11 September 2020

Re: Tahmoor South Amended Project – Surface Water Impacts – Department of Planning, Industry & Environment Request for Information No. 1

Predicted Total Closure (mm):

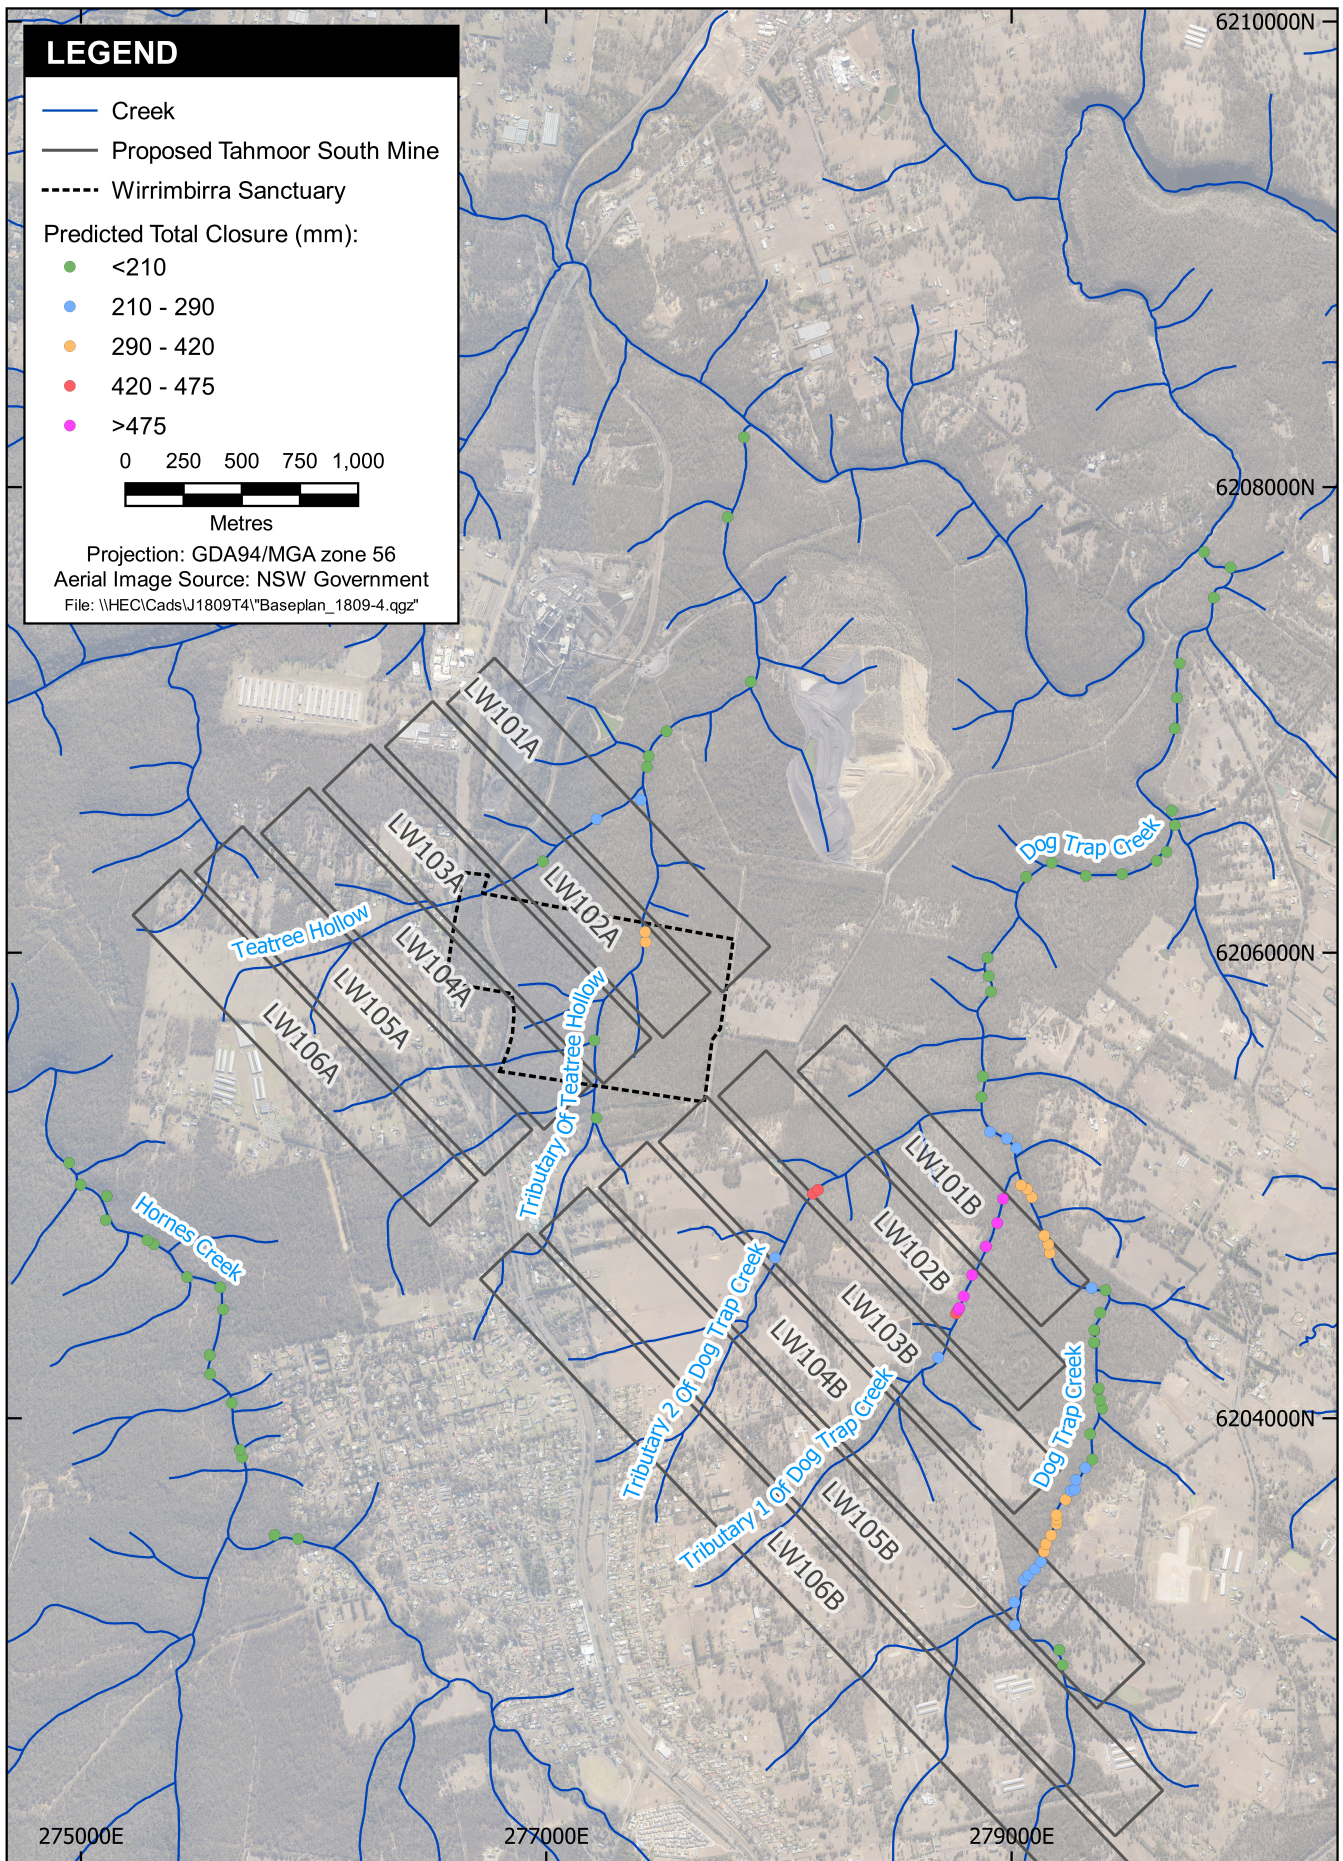
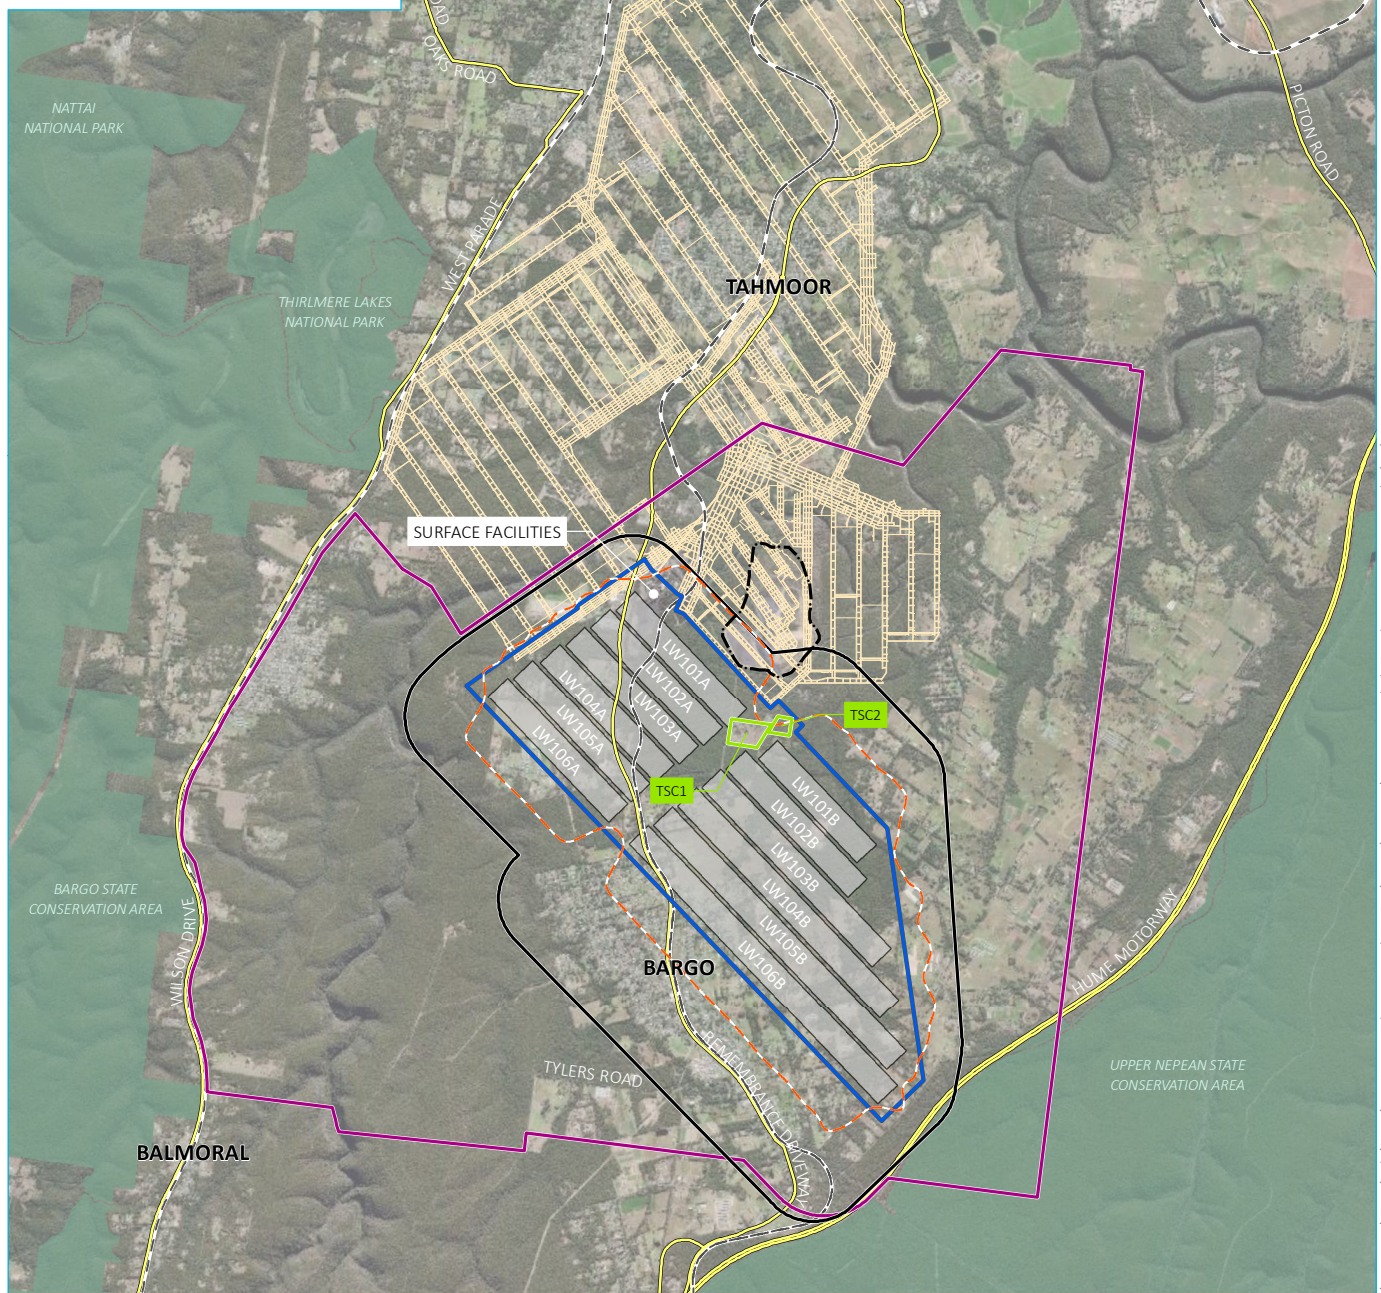
“Clarify the number and location of pools along Tea Tree Hollow, Tea Tree Hollow Tributary 1 and Dog Trap Creek that would potentially be impacted by the proposed development, including the likelihood of “Type 3” impacts to each pool. Note: the numbers referenced in Surface Water Impact Assessment (SWIA) (Section 6.2, Appendix D of the Amended Project Report) are incomplete/inconsistent (refer to table below).

Updated Figures 36 and 37 of the SWIA to include all potentially impacted pools, as well as a location reference for Wirrimbirra Sanctuary.”

Figures 36 and 37 of the SWIA have been updated (expanded) to include all pools. These are given as Figure 1 and Figure 2 below. The table given in the RFI has been completed and is provided as Table 1 below.

There were eight pools mapped in Tea Tree Hollow and five pools mapped on the tributary of Tea Tree Hollow (refer Figure 1). Four of the pools mapped in the lower reaches of Tea Tree Hollow were more than 200 m north-east of LW101A and are therefore highly unlikely to be affected by subsidence-induced fracturing caused by the Tahmoor South Project. Therefore there are four pools mapped in Tea Tree Hollow that are upstream of a point 200 m north-east of LW101A. The predicted valley closure for three of these four pools mapped in Tea Tree Hollow and two of the five pools mapped on the tributary of Tea Tree Hollow is less than 210 mm, indicating that less than 10% of these pools are expected to be impacted. One pool on Tea Tree Hollow and one pool on the tributary of Tea Tree Hollow are predicted to have a total closure of less than 290 mm (less than 20% of pools are expected to be impacted). Two pools on the tributary of Tea Tree Hollow have a predicted total closure of 300 mm and 325 mm respectively. At this total closure prediction, less than 30% of pools are expected to be impacted.

The largest number of pools were mapped on Dog Trap Creek (refer Figure 2). Of these 53 were mapped upstream of a point 200 m north-east of LW101B (pools located further downstream are highly unlikely to be affected by subsidence-induced fracturing caused by the Tahmoor South Project). Six of these 53 pools are predicted to experience closure of less than 210 mm, indicating that less than 10% of these pools are expected to be impacted. Of the 53, 15 pools are predicted to experience total closure of less than 290 mm, indicating less than 20% of pools are expected to be impacted. Of the 53, 18 pools are predicted to experience total closure of less than 420 mm, indicating less than 30% of pools are expected to be impacted. Seven of the 53 pools are predicted to experience closure of less than 475 mm, indicating that less than 40% of these pools are expected to be impacted. The remaining seven of the 53 pools are predicted to experience total closure of more than 475 mm, indicating that more than 40% of these pools are expected to be impacted.
